**Consultation Response from KC,  
Highways Development Management****2025/91019 Fartown Village Hall, Ball Royd Road, Fartown, Huddersfield, HD2 1AN****Change of use from village hall F2(b) to mosque F1(f)****Date Responded: 20/02/2026****Responding Officer: CNB****Responding Ref: K5-9NE/29**

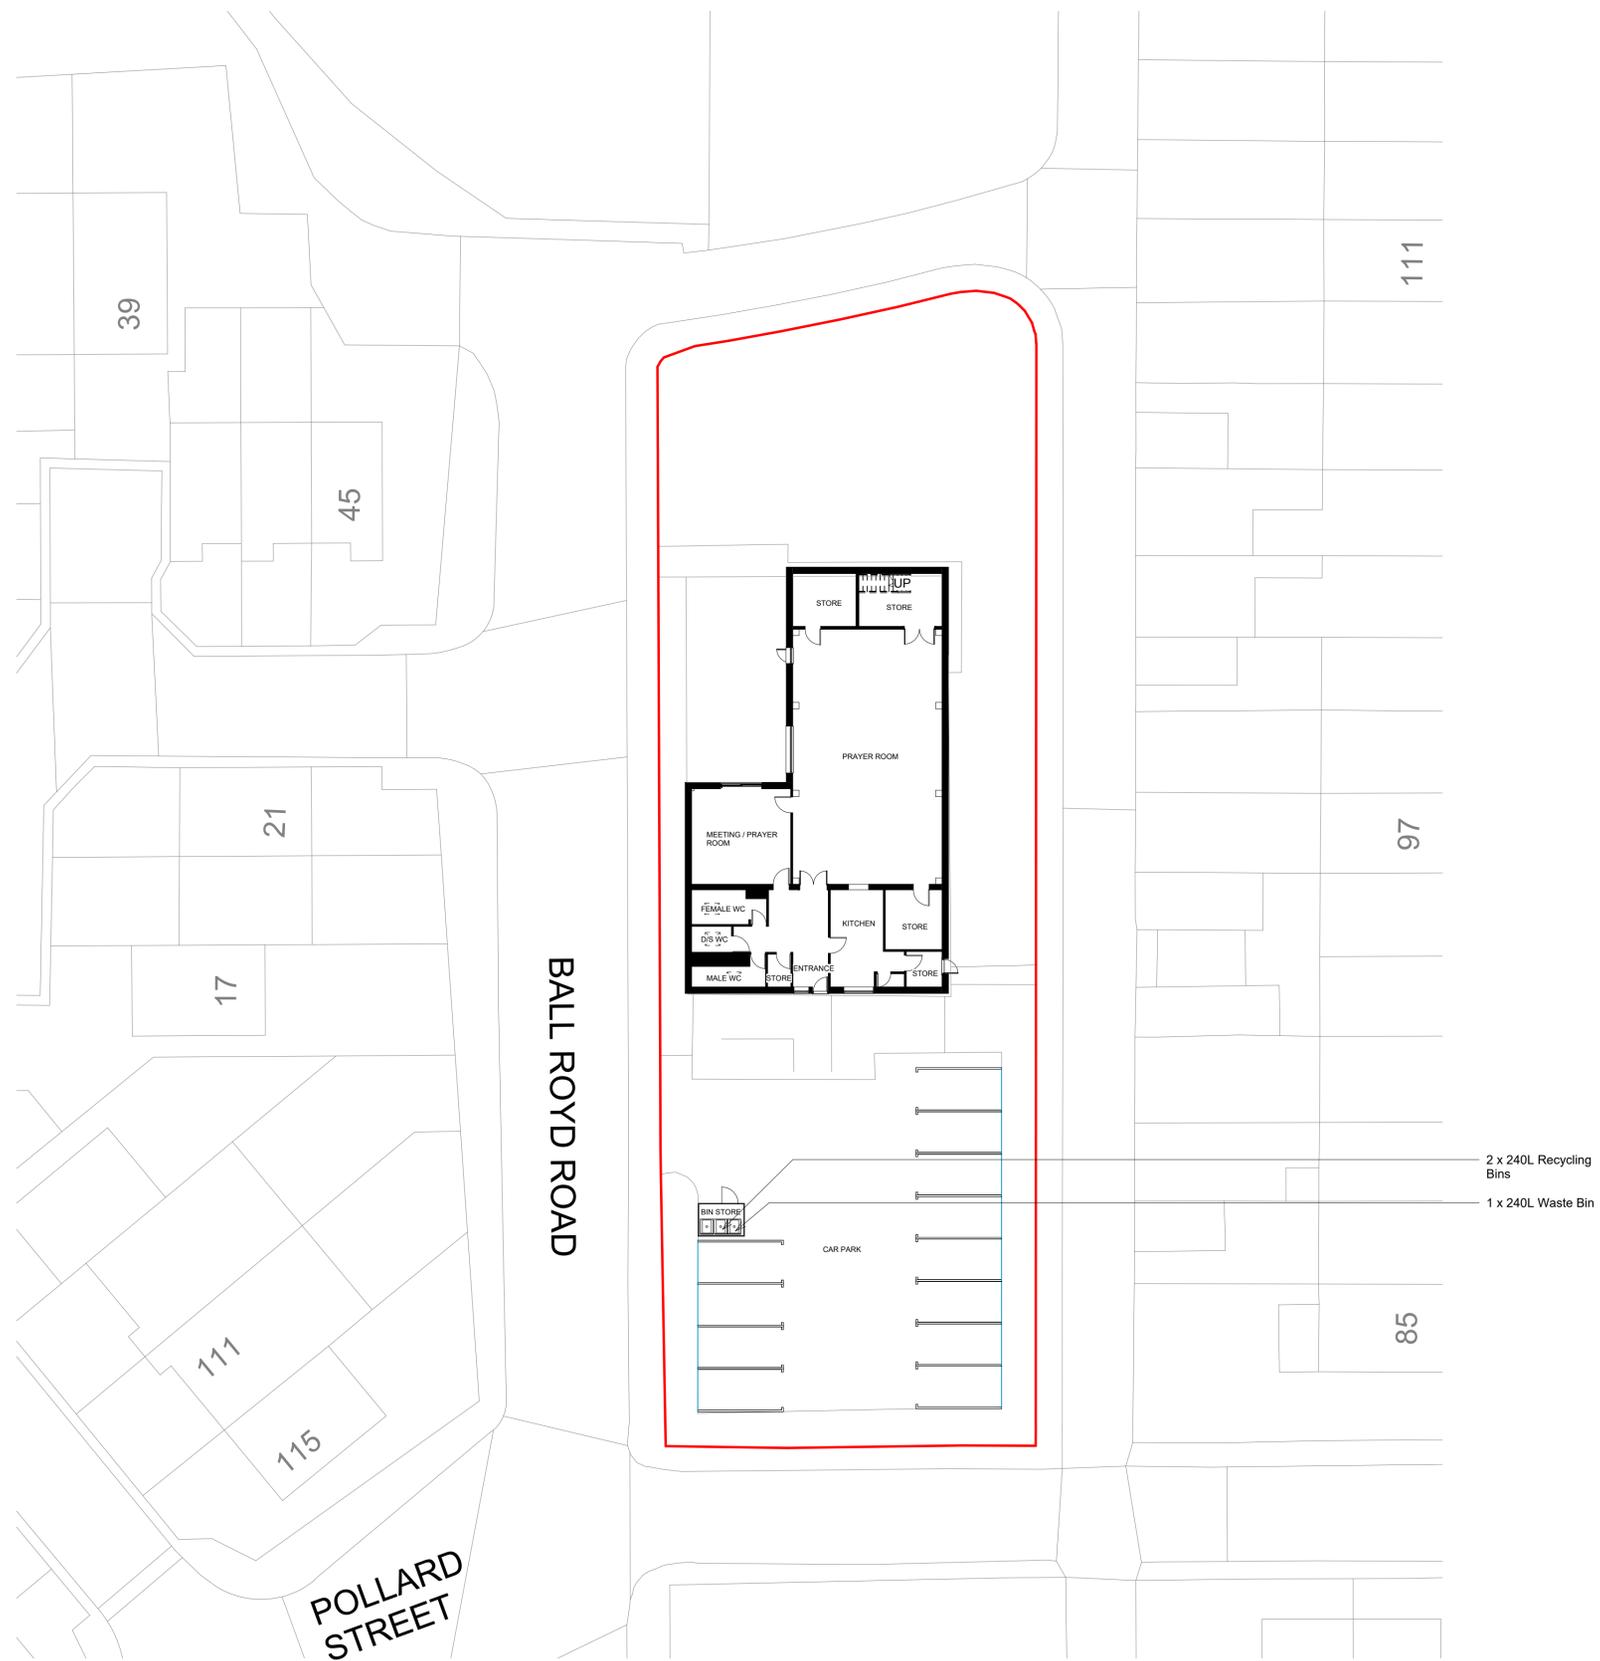
The only concern relating to trip generation we have is that the proposed parking supply would not meet the demand. The applicant has proposed 12 marked car parking spaces on the car park (as shown on drawing No (100)05 Parking Layout) and we have concerns that this will overflow on to the surrounding highway network. It should be noted that there are some on-street parking availability surrounding the site, with approximately space for 8 cars adjacent to the site along Ball Royd Road and space for 3 cars available to the front of the site along Road From Side of 40 Ball Royd Road to Blackhouse Road, the other surrounding roads are too narrow to accommodate any on-street parking without causing obstruction.

During busy times (Friday prayers and other events) it may be possible to “stack” additional cars within the car park given the shared arrival and departure times, however this would need parking marshals to guide the cars into a stacked formation to still allow egress. In order to do this, we would need to see a Car Parking Management Plan that provides details of the proposed trip generation, parking demand and how this demand will be managed without causing obstruction on the surrounding highway network, including during busy times (Friday prayers) and events where parking demand would be expected to be high. The Car Parking Management Plan should also contain details of mitigation in the event that anti-social parking occurs due to the operation of the application site and obstruction of the highway or accesses occurs, this may include the funding of TRO parking controls on the impacted roads and funding should be made available by the applicant to pay for this (the current cost of a TRO and works is approximately £10,000), this should be included within a s106 agreement. The Car Parking Management Plan should be conditioned.

Due to the limited space within the car park, we would expect waste collection to be made from the kerbside on Ball Royd Lane rather than having a Kirklees refuse truck access the site. Details of waste storage and bin requirements should be obtained from the Kirklees Waste Strategy team.

The development shall not be brought into use until a Car Park Management Plan has been submitted to and approved in writing by the Local Planning Authority. The Car Park Management Plan shall include details of:

- i. Trip generation and expected parking demand at the site
- ii. Resident Liaison member of staff and contact details
- iii. Method(s) of informing resident of events taking place where high volumes of guests are expected. (for example this might include leaflet, text, website, notice board etc).
- iv. the use of car park attendant/s and marshals
- v. The overflow parking plan and the use of stacking within the existing car park.
- vi. Monitoring of on-street parking generated by the development and the means of mitigation in the event of repeated anti-social parking and obstruction.
- vii. Promotion of the use of sustainable and active travel
- viii. Mechanism for review of the Car Park Management Plan
